**SITE PLAN CONTROL APPLICATION
DELEGATED AUTHORITY REPORT
PLANNING, REAL ESTATE AND ECONOMIC DEVELOPMENT DEPARTMENT**

Site Location: 3447 (3449) Old Almonte Road

File No.: D07-12-22-0048

This SITE PLAN CONTROL application submitted by Jessie Smith, CSV Architects, on behalf of the City of Ottawa, is APPROVED as shown on the following plan(s):

Drawing Title: **GRADING, DRAINAGE, SERVING, SEDIMENT AND EROSION CONTROL PLAN**

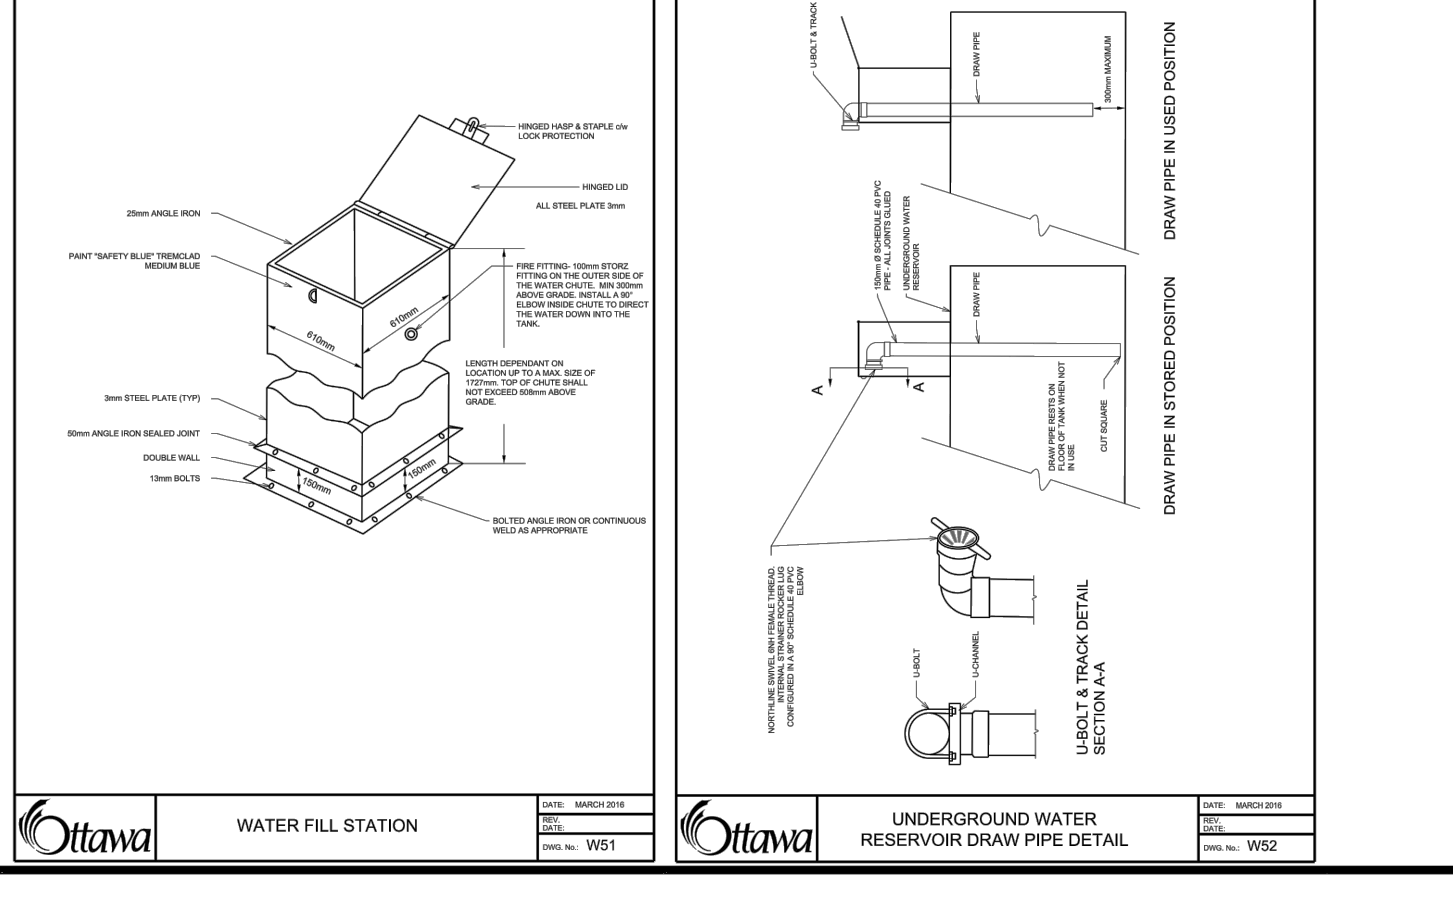
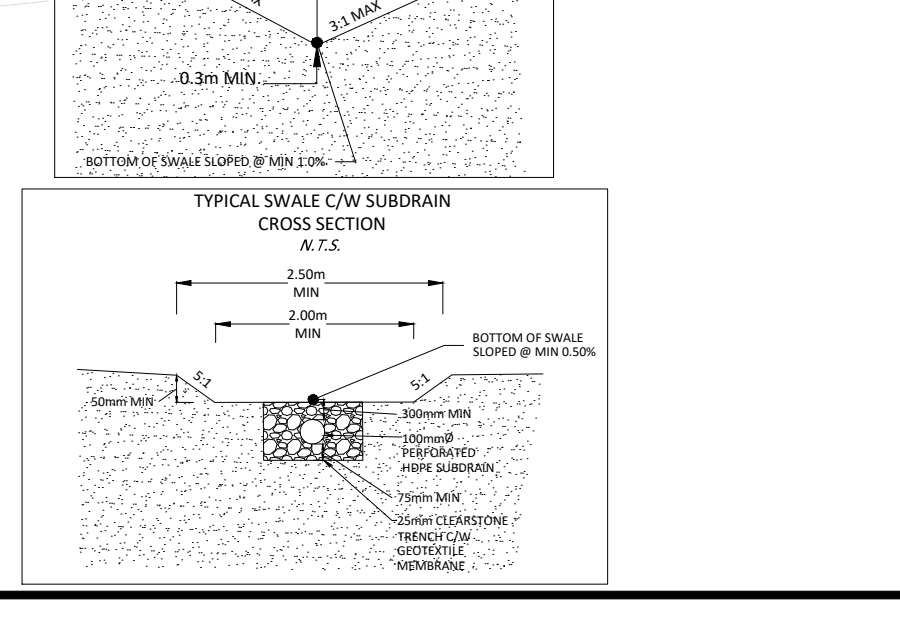
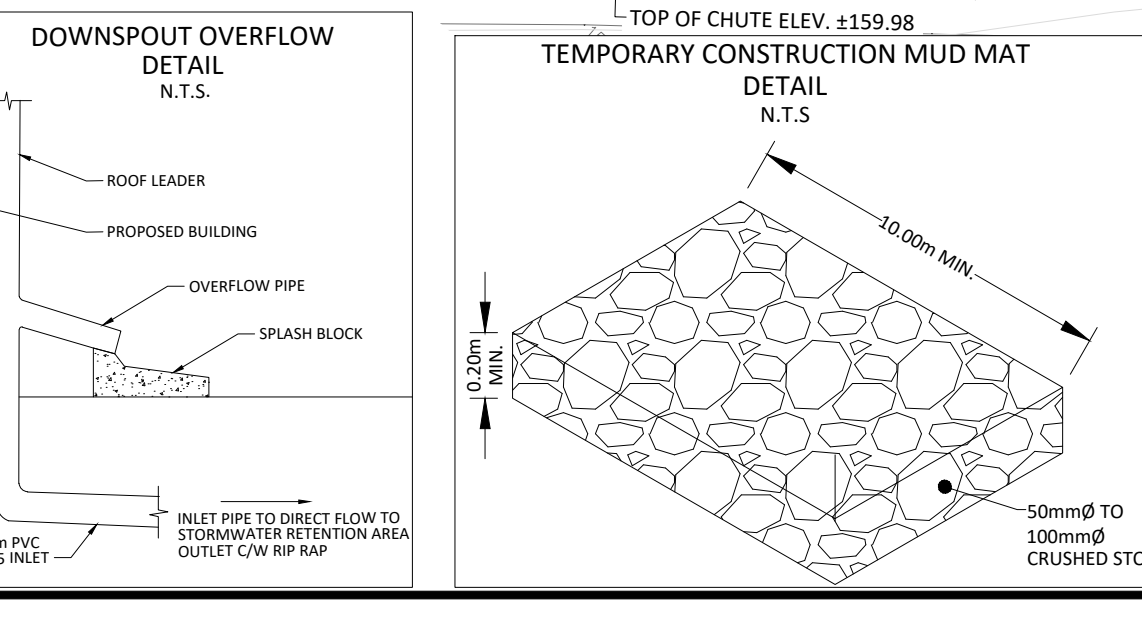
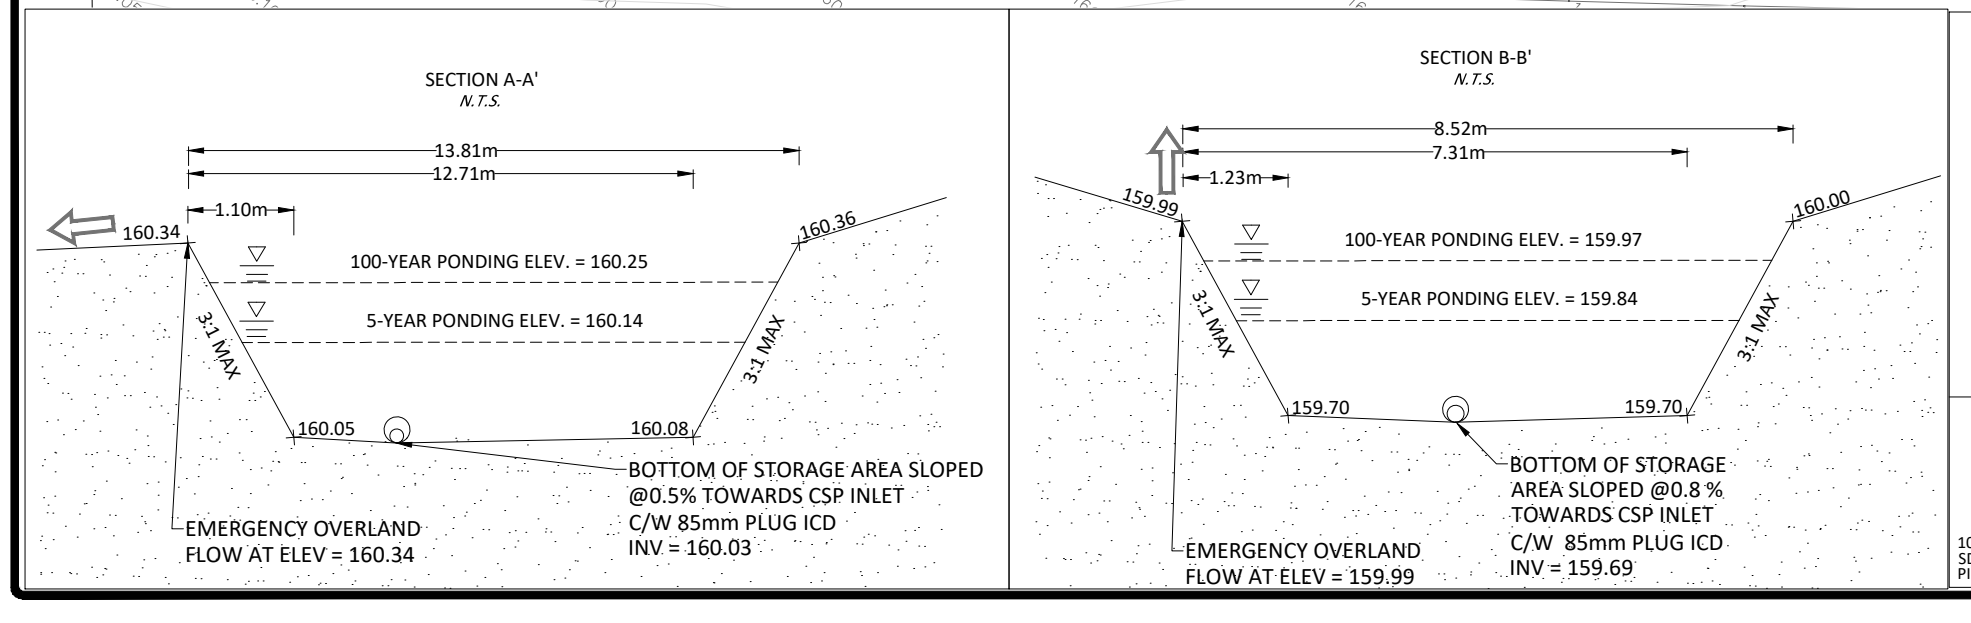
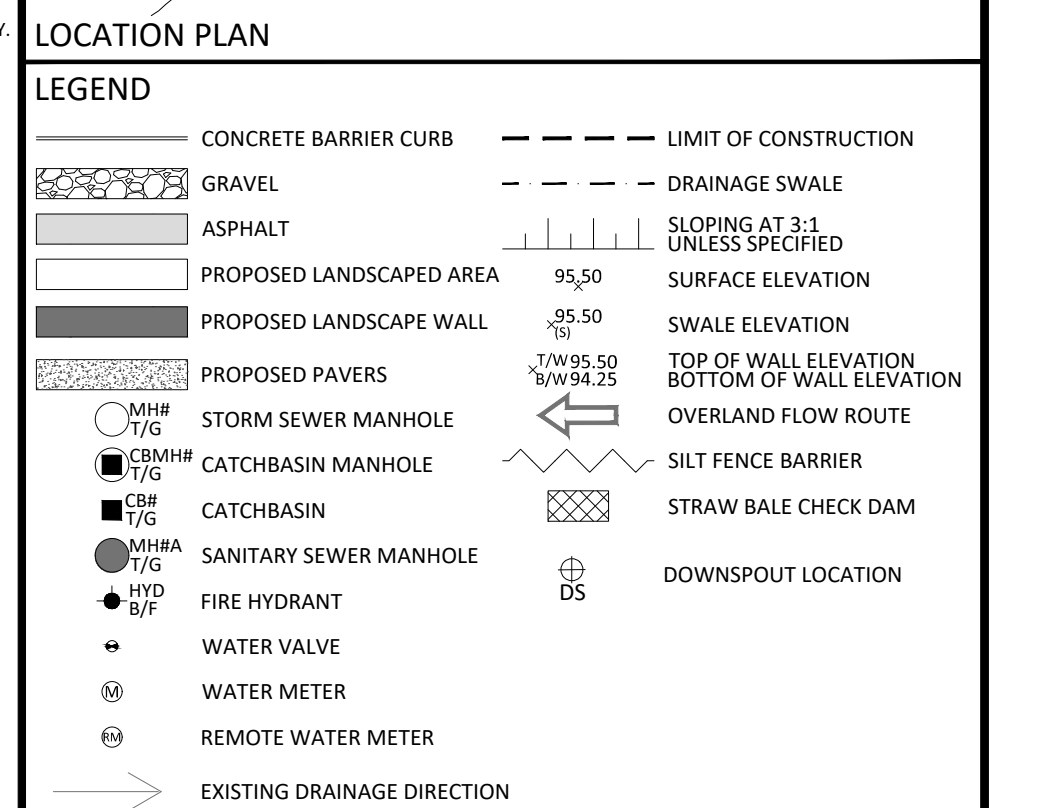
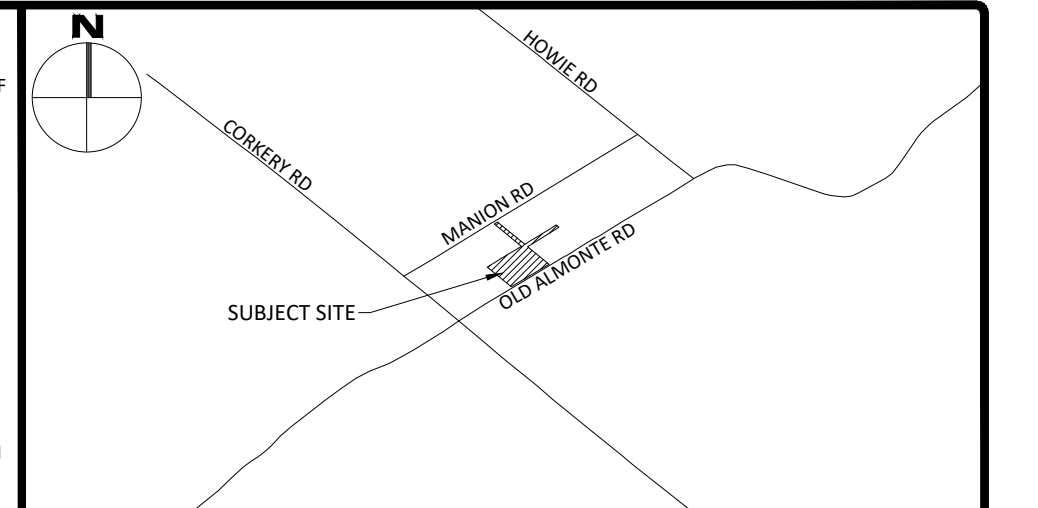
The Owner acknowledges and agrees that with the Finish Floor Elevation (160.54 m) closely matching the finished external grades at the building (160.45 m – 160.53 m) with the entrance doors at the external grade elevation, this condition exposes the proposed building interior to an increased potential of future flooding caused by rainfall or snowfall events. The proposed development includes an upstand wall and waterproofed foundation wall to address these potential flooding concerns, as illustrated on the Grading, Drainage, Servicing, Sediment, and Erosion Control plan prepared by and sealed by the designing engineer from McIntosh Perry. Development Review staff have concerns that the proposed design may have an increased risk of flooding over the long-term and as such, strongly recommend the Owner conduct additional investigation to help mitigate future potential flooding.

- Development review staff identified potential flooding concerns with the proposed proximity between the Finish Floor Elevation and adjacent grades. The engineer consultant proposed an upstand wall and waterproofing as an alternative to increasing the Finish Floor Elevation. City engineer staff are not fully satisfied these alternatives will mitigate potential future flooding, but are willing to proceed as the engineer consultant has assured their effectiveness. However, staff strongly recommend additional investigation into future flooding mitigation measures in anticipation of increased storm intensity and frequency, temperature fluctuation, and weather unpredictability. This is reflected in the conditions above.
